1. System no.1 (adjacent Ford Road) arrangements are now much improved.
2. Two RWP's are connecting into the permeable pavement from the refuse store – can these be connected into the hydrobrake chamber associated with outfall no.1.
3. Tank beneath building;
 - a) It is noted that the tank has had the orifice removed and now relies on a 150mm outlet, low level hydrobrake and sealed system to operate. The sealed part of the system will need to be very robust.
 - b) Bolted steel tank sections noted but unclear how it will be possible to unbolt them, particularly any bolts on the upper rim of the tank ie. below floor/void.
 - c) Tanks would need to be protected against corrosion both inside and out.
 - d) The upstream rodding point is shown on the section but not on the plan. Specify as 300mm diameter pipe.
 - e) Show tank gradient on section.

Further to your email dated the 2nd April 2020 to Juan Baeza and David Spring, I would comment as follows.

Please find attached our revised drainage drawing E19-003-1000A and micro drainage calculations along with structural sketch E19-003-SK2000 showing the support to the raised tanks.

| -     | EX-063-1000 | A      |

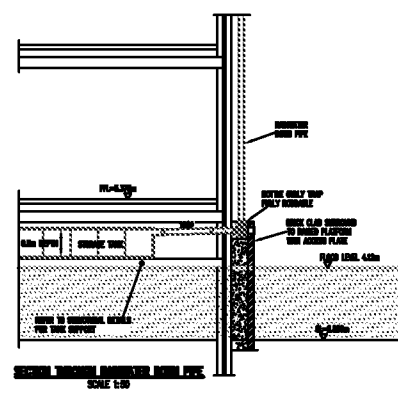
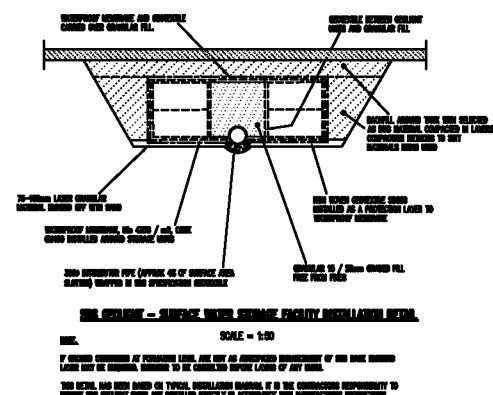
1. Fluvial flood water (designing against the 1 in 100 yr +105% modelled event) will still overwhelm the car park drainage and parts of the roof drainage system (The roof water currently discharges into the system serving the permeable surfaced car park). Consider separating the roof water from the system serving the permeable pavement. I.e. provide at least two separate outfalls (possibly three bearing in mind item 2 below) to the watercourse/s with independent hydrobrakes and flap valves. Sealing all components of the roof water system below 4.12m AOD to prevent fluvial flood water inundation i.e. sealed manhole covers, etc. Accept that the permeable pavement system will be inundated with fluvial flood water, since there is little that can be done to prevent flood water entry. Compensate for this by overdesigning the permeable pavement storage (factor to be agreed).

Please find attached a copy of drawing E19-003-1000 A which has been revised as follows.

The roof drainage from each building has been separated out from the car park drainage. Each system has its own outfall into the adjacent watercourse. All manholes which have cover levels below 4.12m AOD, will have sealed bolt down covers. The storage tank for the roof water runoff by Ford Road has been set as high as possible to keep the majority above the top of ditch level (2.0m AOD). Therefore should the ditch become surcharged the storage for the roof water runoff will not become inundated. The attenuation below the car park has been sized to suit the car park runoff ignoring the voided stone below the permeable paving. The crates below the car park provide 73 Cu.M of attenuation. The 30% voided stone below the car park will provide approximately an extra 150 Cu.M of attenuation.

SITE DRAINAGE PLAN
SCALE 1:200

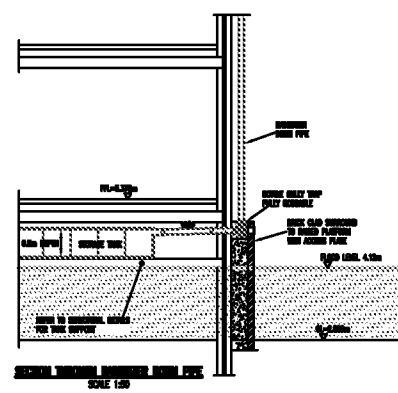
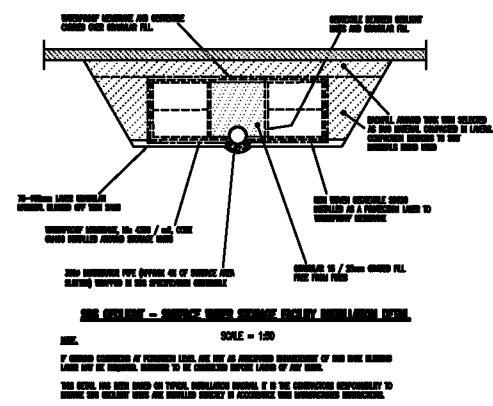
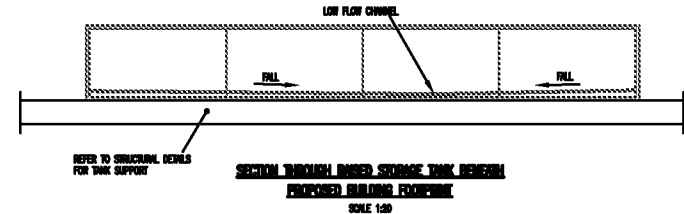
2. Tank access for maintenance is still an issue. Whilst an attempt has been made to address this, the western tanks having slightly better access than the eastern tanks, however, this still falls short of what is required. Perhaps consider moving the western storage from beneath the building to the area between Ford Rd and the building, ensuring cover levels are set above 4.12m AOD and sealed for good measure? Can this option be achieved? Connect this system independently to the northern watercourse.

3. Suitable access to the eastern tanks –including the orifice control is a challenge. Full safe access is required to all tank sections/link pipes, etc for inspection/cleaning. The fact that access points will be at a height of around 1.5m above ground level is also a key point here and a safe form of access will need to be provided. Whilst a low flow channel and rodding points will provide some help, it is not considered a total solution and needs further investigation to see what is possible. This is where the building would benefit from a blue roof arrangement as an alternative arrangement.....

4. Orifices to be protected by perforated filters to reduce risk of blockage.

5. All RWP's to connect to tanks at soffit to soffit level and somehow incorporate silt traps (roofs still produce siltation due to leaf fall collected in gutters/moss growing on the roof, etc). Provide a safe means of access to rodding eyes/silt traps.

6. Both systems to store 1 in 100 year event + 40% (without flooding) and designed against a surcharged outfall ie. assume ditch is full to top of bank. Also simulate discharge (roof water systems) against predicted flood level of 4.12m AOD.

7. Details of low flow channel for tanks/gradient/tank material/link pipes to be min 300mm diameter.

Drawing E19-003-SK1000 A indicates a scheme which locates the attenuation outside the building towards Ford Road. The drainage from the roof also has its own outfall to the watercourse. All rainwater pipes have sumps to remove silt and allow easy maintenance.

Drawing E19-003-1000 A and SK2000 show additional details on access and maintenance of the high level suspended tanks. The tank supports are shown in more detail on SK2000. As the majority of the supports are below the tank in the form of a steel plate and secondary beams. The primary beams span to supporting walls. All the steel structure will be galvanised. This layout will allow plenty of safe access to maintain the tanks. The tanks themselves will be sectional steel tanks which will be bolted together insitu. They can be jettied out and cleaned. If required they can also be unbolted cleaned and put back together. Each of the tanks will have plates welded inside to create 'V' shape in the base to form a low flow channel. All the rainwater pipes will have external high level gully set above the flood level. This will take the form of a brick column with a cover which can then be removed to allow access to the gulley. A detail has been shown on drawing SK1000 A. The roof of the block is designed to emulate a traditional sloping tiled roof. Whilst there is a small flat roof area, taking account of the necessary roof penetrations, including an automatic opening smoke vent (AOV) renders a "blue roof" impractical.

As each system now has its own outfall, we will be using hydrobrakes in manholes which are much simpler to keep clean and free from blockages.

All the RWP's are now shown connection to the soffit of the tanks. Silt traps are shown as noted above. The silt traps and rodding eyes are set 1.5m above ground level, (about shoulder height). This means they are accessible from ground level. If higher access is required a small scaffold tower can be used.

The watercourse has been taken as surcharged and a proprietary Checkmate valve shown. Details are attached with the micro drainage calculations for the surface water drainage.

Details have been added to drawing E19-003-1000 A in terms of the tank type, gradients and low flow channels.
